City of Albuquerque

**Re: Heights Hair Styling Revised Grading and Drainage Plan
Engineer's Stamp Dated 3-15-02, (J21/D41)**

Based on the information contained in your submittal dated 3-20-02, the above referenced plan is not approved for Building Permit until the following comments are addressed:

A PROPOSED GRADING AND DRAINAGE PLAN

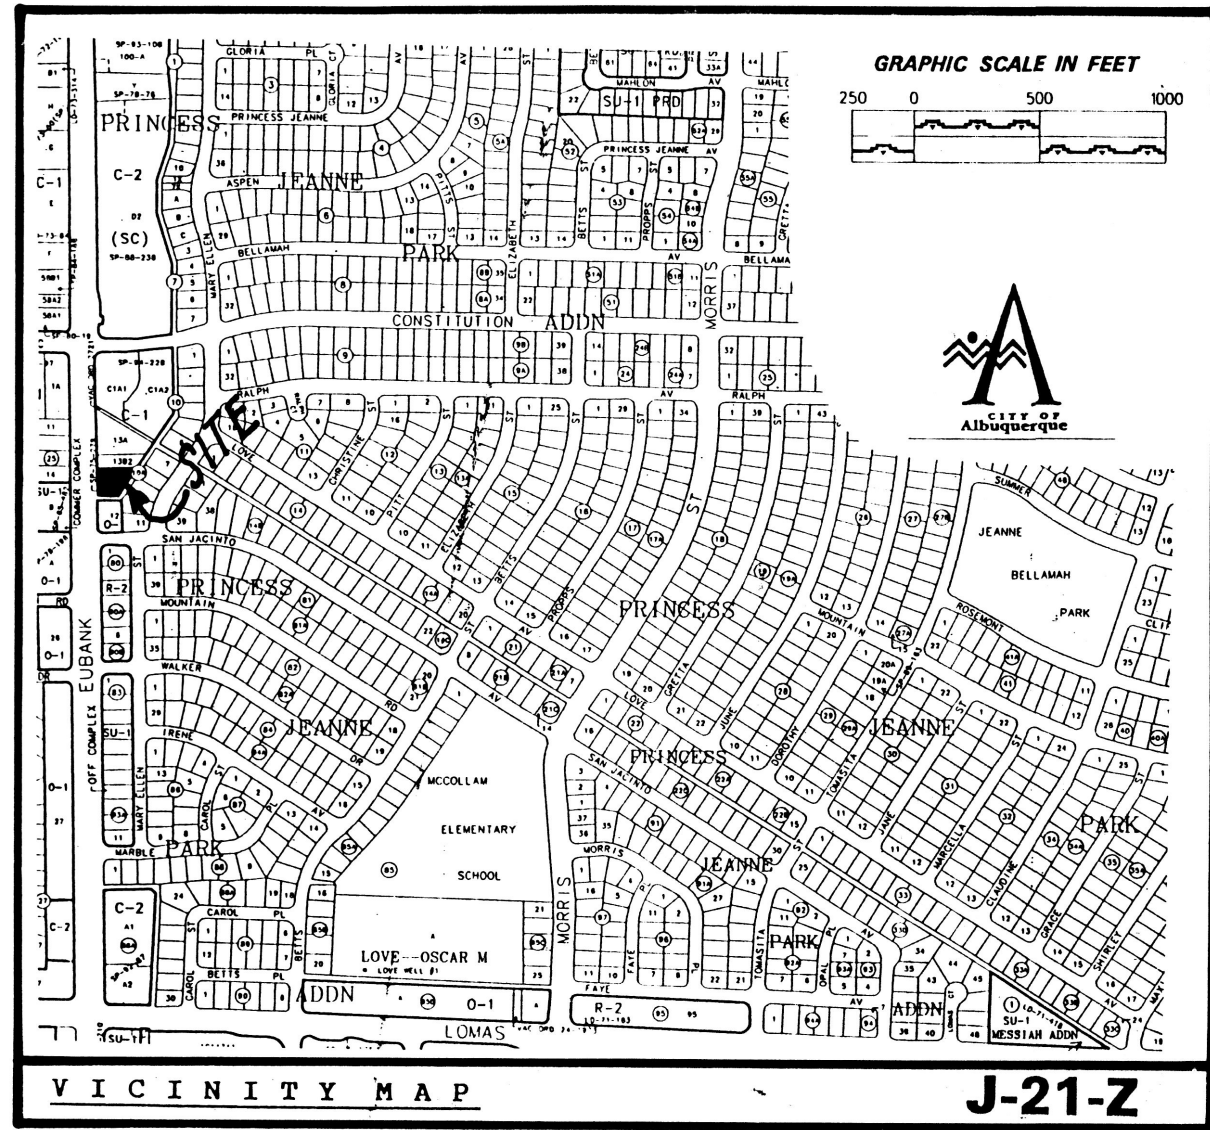
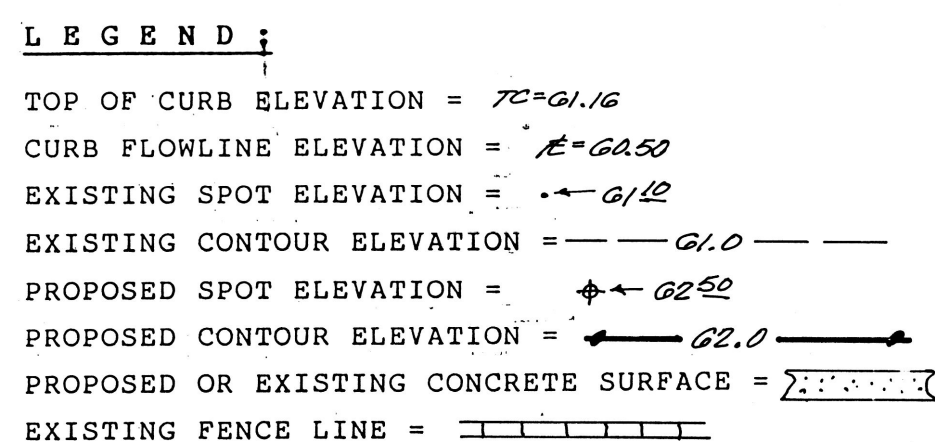
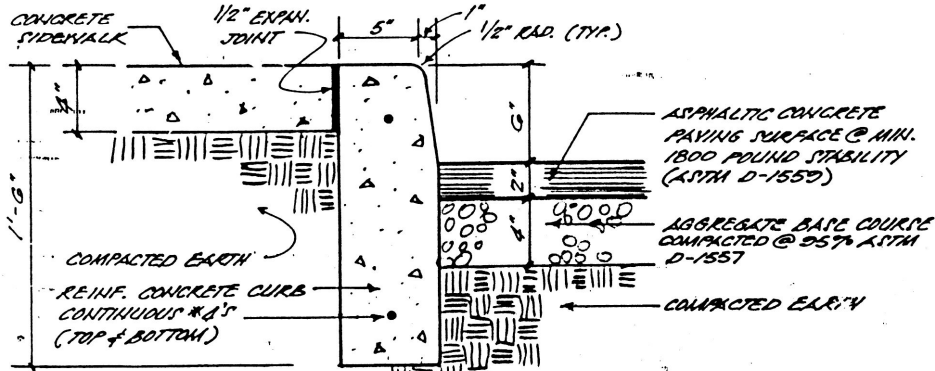
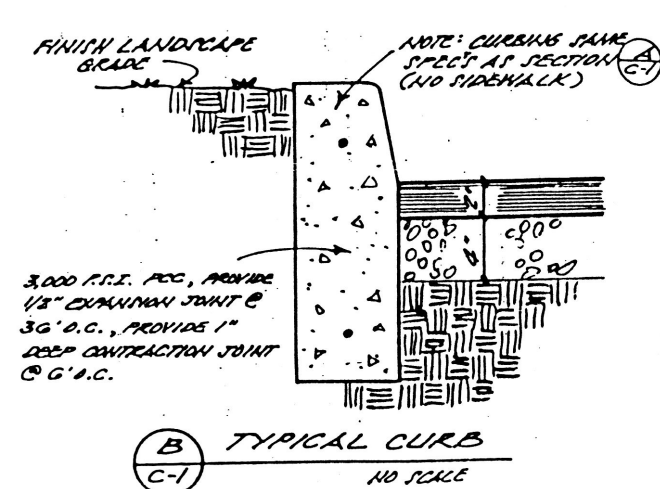
- If you are accepting offsite flows from the public alley, please quantify the flow coming down the alley and the flow that is entering the private property.
- If you decide to block historical flows from the property, it will be your responsibility to direct the runoff along the alley exiting out to Eubank. Otherwise, a public drainage easement for accepting offsite flows across private property will be required.
- Is the entire alley paved?
- What is the purpose of the existing asphalt berm in the public alley?
